Rosefield Solar Farm

Schedule of Changes to the draft DCO (Tracked)

EN010158/APP/8.1.65
Revision 035
Change-ApplicationDeadline 4
June 2026
Rosefield Energyfarm Limited

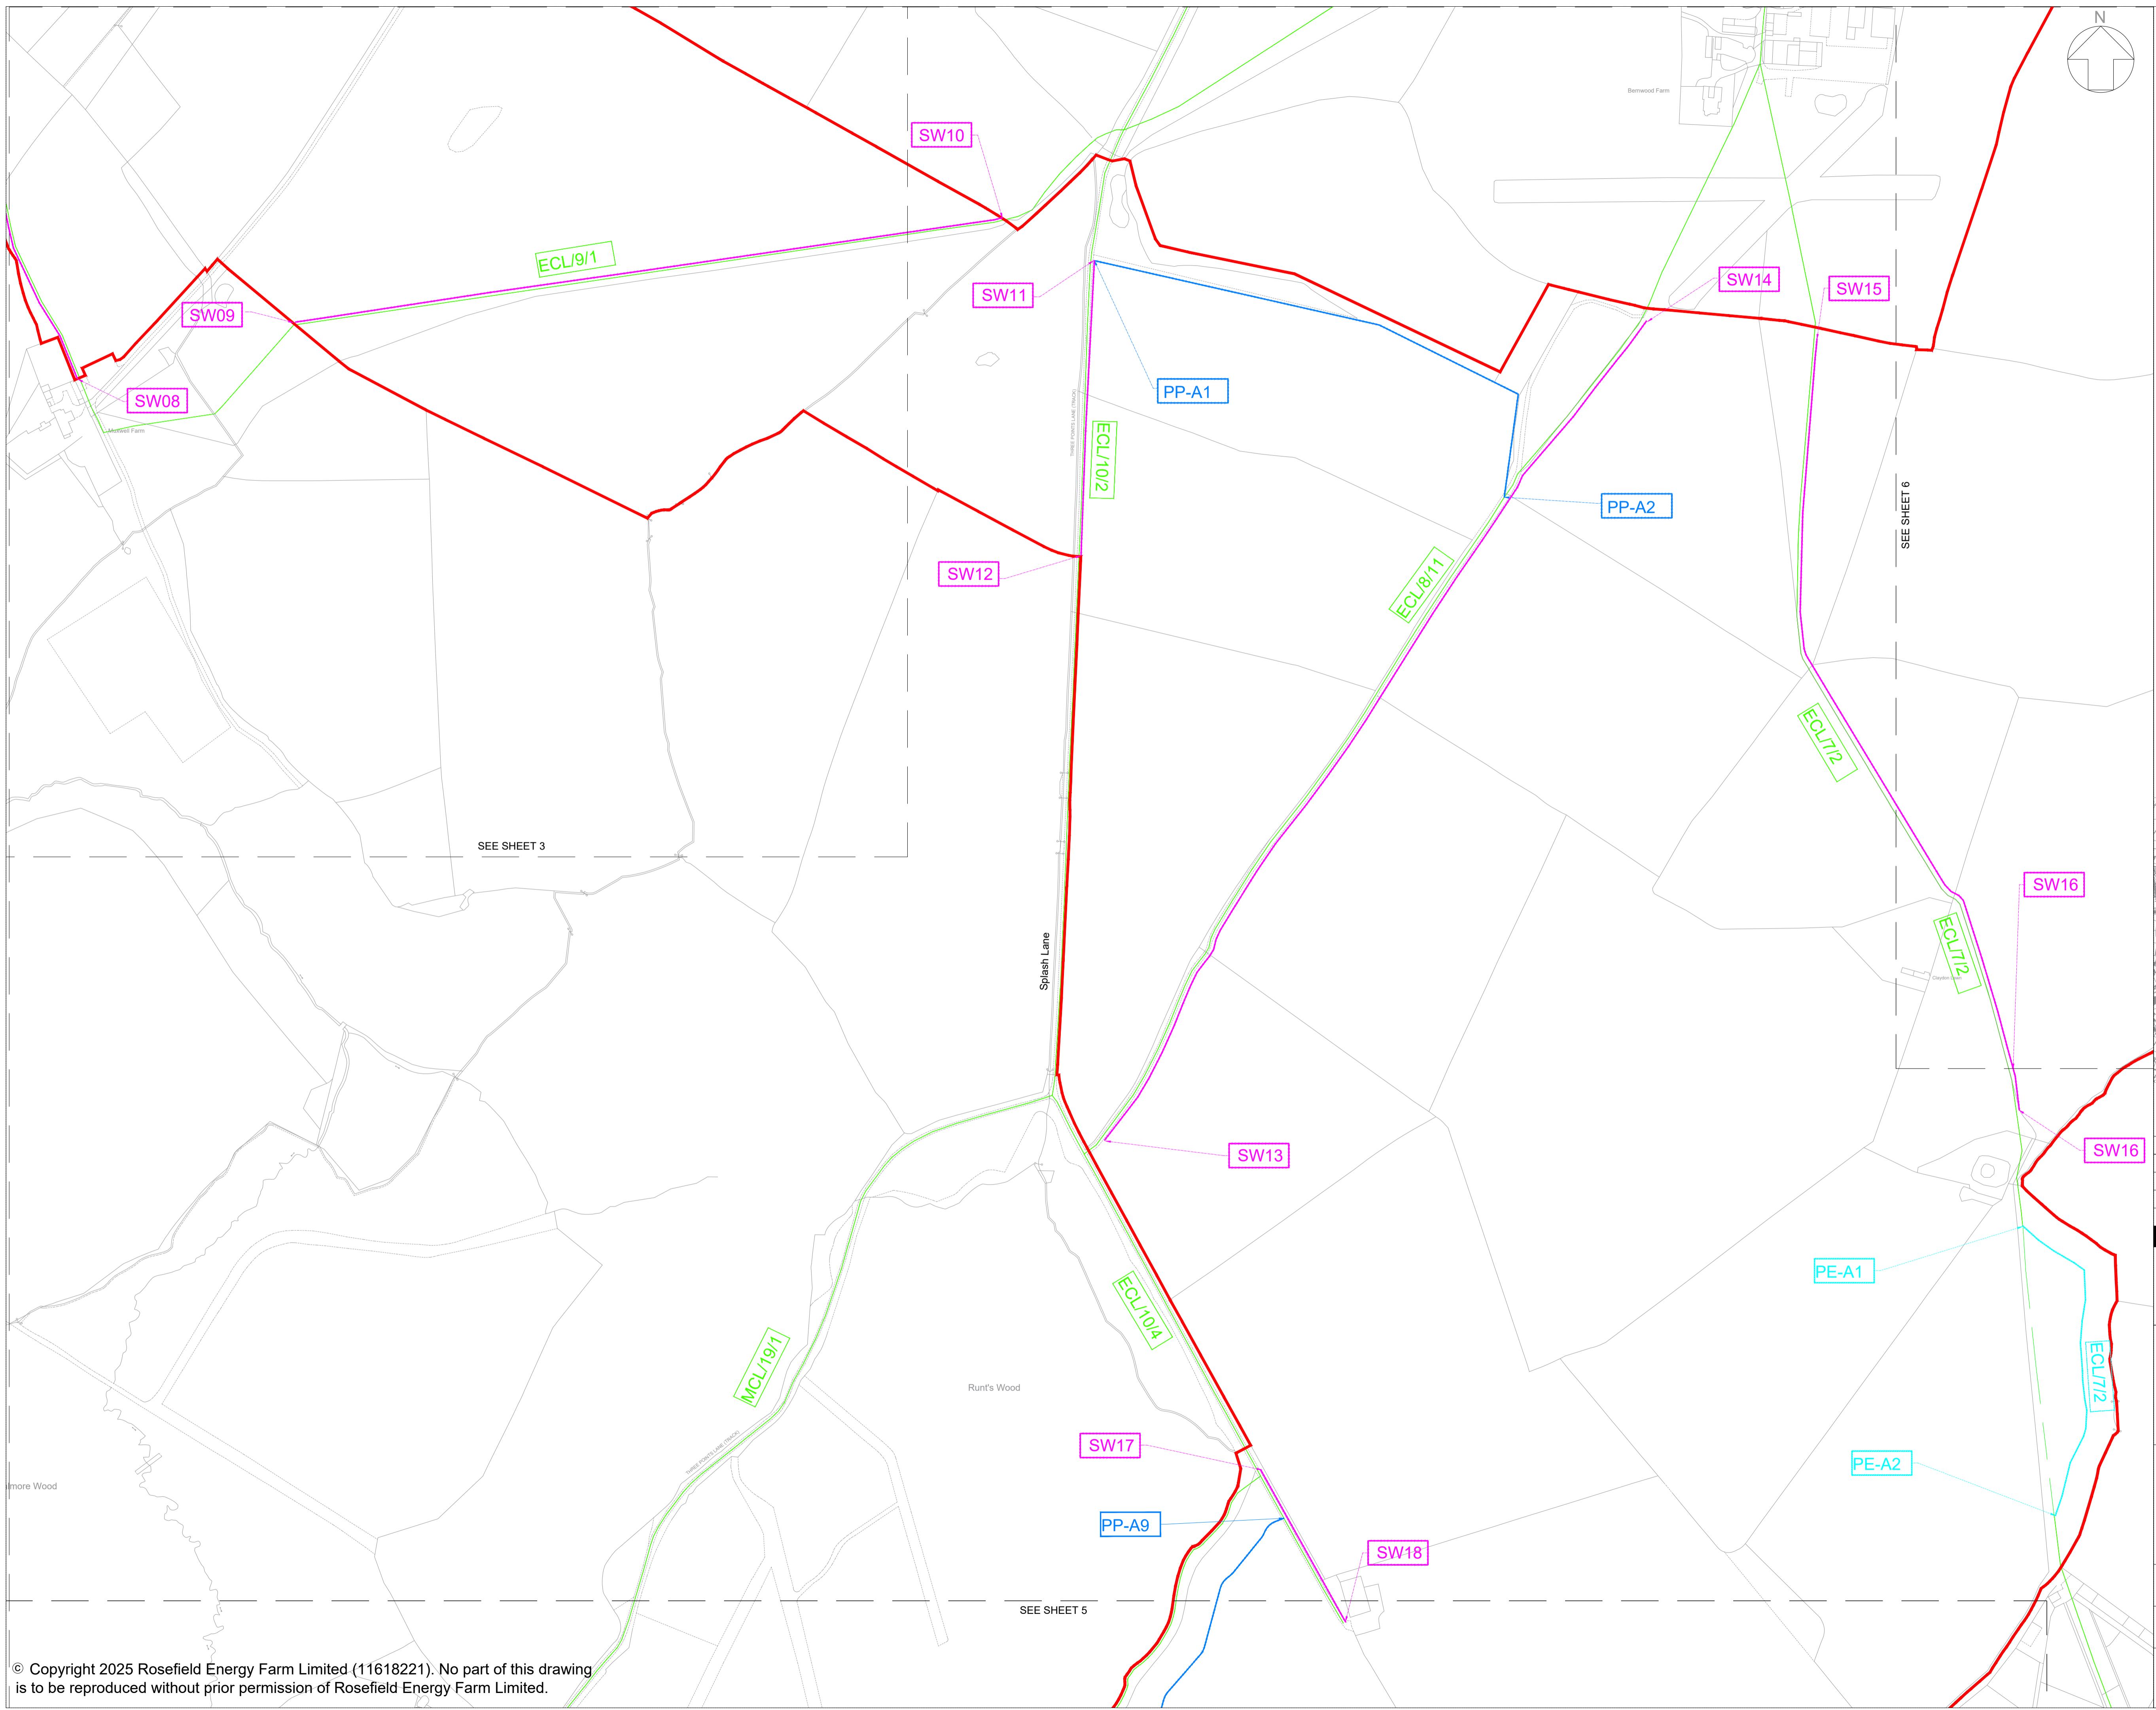
<table><tr> <th><u>(1)</u> <u>Area</u></th><th><u>(2)</u> <u>Public right of way to be stopped up</u></th><th><u>(3)</u> <u>Extent of stopping up</u></th><th><u>(4)</u> <u>New public right of way to be substituted / provided</u></th></tr><tr> <td><u>District of Buckinghamshire</u></td><td><u>SCL/13/1 and SCL/13/2</u></td><td><u>For a distance of 1,210 metres between points PE-A7 and PE-A3 as shown on sheet 1 of the streets, access and rights of way plans.</u></td><td><u>New public footpath of minimum width of 2m to be provided between points PE-A7, PE-A5 and PE-A4 and PE-A3 as shown by a cyan line on sheet 1 of the streets, rights of way and access plans.</u></td></tr><tr> <td><u>District of Buckinghamshire</u></td><td><u>SCL/12/2</u></td><td><u>For a distance of 190 metres between points PE-A7 and point PE-A10 as shown on sheet 1 of the streets, access and rights of way plans.</u></td><td><u>New public footpath of minimum width of 2m to be provided between points PE-A7, PE-A5 and its intersection with SCL/12/1 as shown by a cyan line on sheet 1 of the streets, rights of way and access plans.</u></td></tr></table>

<u>(1)</u> <u>Area</u>	<u>(2)</u> <u>Public right of way to be stopped up</u>	<u>(3)</u> <u>Extent of stopping up</u>	<u>(4)</u> <u>New public right of way to be substituted / provided</u>	<u>District of Buckinghamshire</u>	<u>SCL/13/1 and SCL/13/2</u>	<u>For a distance of 1,210 metres between points PE-A7 and PE-A3 as shown on sheet 1 of the streets, access and rights of way plans.</u>	<u>New public footpath of minimum width of 2m to be provided between points PE-A7, PE-A5 and PE-A4 and PE-A3 as shown by a cyan line on sheet 1 of the streets, rights of way and access plans.</u>	<u>District of Buckinghamshire</u>	<u>SCL/12/2</u>	<u>For a distance of 190 metres between points PE-A7 and point PE-A10 as shown on sheet 1 of the streets, access and rights of way plans.</u>	<u>New public footpath of minimum width of 2m to be provided between points PE-A7, PE-A5 and its intersection with SCL/12/1 as shown by a cyan line on sheet 1 of the streets, rights of way and access plans.</u>	<u>In response to Buckinghamshire Council's request in its Local Impact Report [REP1-112] and in engagement with the Council at Issue Specific Hearing 1 where Council requested this be included on the face of the draft DCO.</u>	<u>4</u>
<u>(1)</u> <u>Area</u>	<u>(2)</u> <u>Public right of way to be stopped up</u>	<u>(3)</u> <u>Extent of stopping up</u>	<u>(4)</u> <u>New public right of way to be substituted / provided</u>												
<u>District of Buckinghamshire</u>	<u>SCL/13/1 and SCL/13/2</u>	<u>For a distance of 1,210 metres between points PE-A7 and PE-A3 as shown on sheet 1 of the streets, access and rights of way plans.</u>	<u>New public footpath of minimum width of 2m to be provided between points PE-A7, PE-A5 and PE-A4 and PE-A3 as shown by a cyan line on sheet 1 of the streets, rights of way and access plans.</u>												
<u>District of Buckinghamshire</u>	<u>SCL/12/2</u>	<u>For a distance of 190 metres between points PE-A7 and point PE-A10 as shown on sheet 1 of the streets, access and rights of way plans.</u>	<u>New public footpath of minimum width of 2m to be provided between points PE-A7, PE-A5 and its intersection with SCL/12/1 as shown by a cyan line on sheet 1 of the streets, rights of way and access plans.</u>
